19 July 2021

# Proposed State Significant Development (SSD-9138102) – Westlink Industrial Estate Response to Application

We are writing in response to the public exhibition of the State Significant Development Application for an Industrial Estate (Proposed Development) at 290-308 Aldington Road, 59-62 Abbotts Road and 63 Abbotts Road, Kemps Creek (Lots 11-13 DP 253503) (Site).

## Plan Detention Basin and Amenities

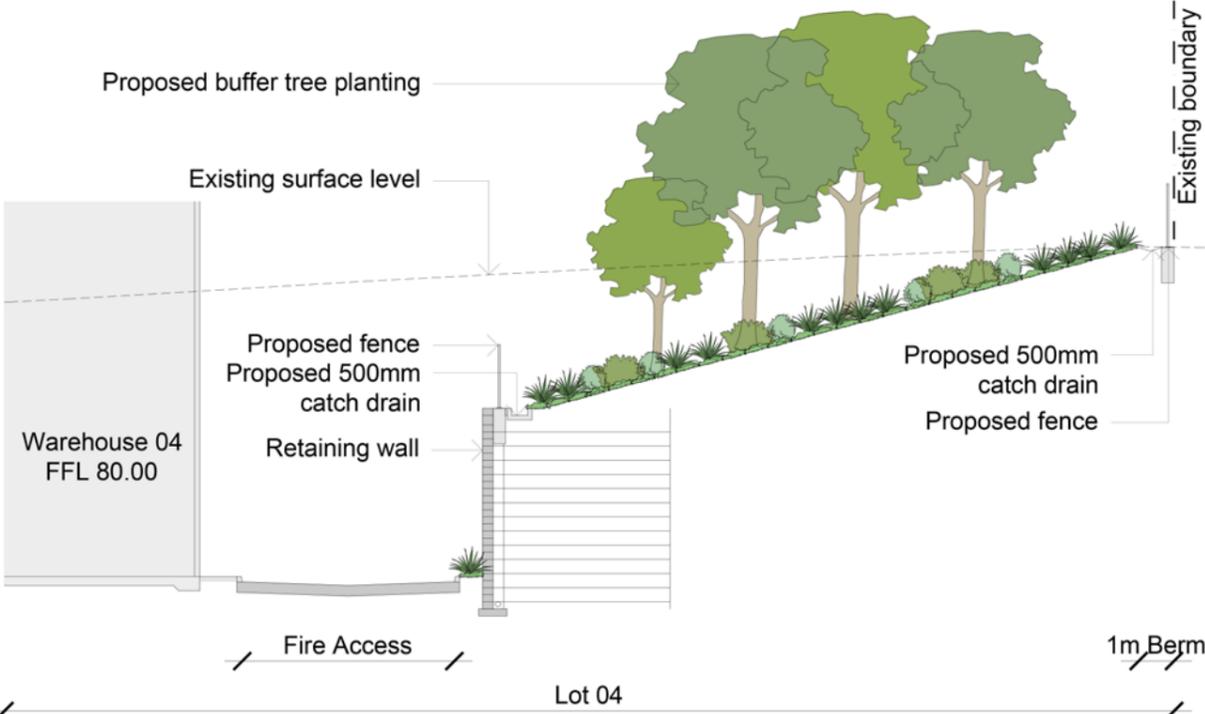
The site is located within the 8km wildlife buffer for Western Sydney Airport. The proposed development does have the potential to attract wildlife to the site through the proposed landscaping, onsite detention basin, waste management (during construction and operations). A review of the landscape plans should be undertaken by an appropriately qualified ecologist to ensure the landscape species selected minimise wildlife attraction.

Insufficient detail has been provided within the EIS to identify how the onsite detention basin and temporary bio-retention basin and sedimentation basin will be designed, managed and monitored to minimise wildlife attraction. It is noted that there is conflicting information through the EIS documentation in relation to the size of the on-site detention basin, but assuming it is 10, 974m<sup>2</sup>, it does have the potential to attract wildlife.

A wildlife management and monitoring plan is to be prepared by a suitably qualified aviation ecologist. The plan must address:

- Design, management and monitoring of the onsite detention basin and temporary bioretention and sediment basins.
- Landscaping species selection and maintenance.
- The design and management of waste storage areas/receptacles during construction and operational phases.
- External handling and storage of organic materials.
- Any compost areas for food waste.
- Monitoring and management of any wildlife.

All recommendations from the wildlife management and monitoring plan must be implemented. The detention basins, landscape plan and waste management plan are to be amended to include any recommendations from that plan.
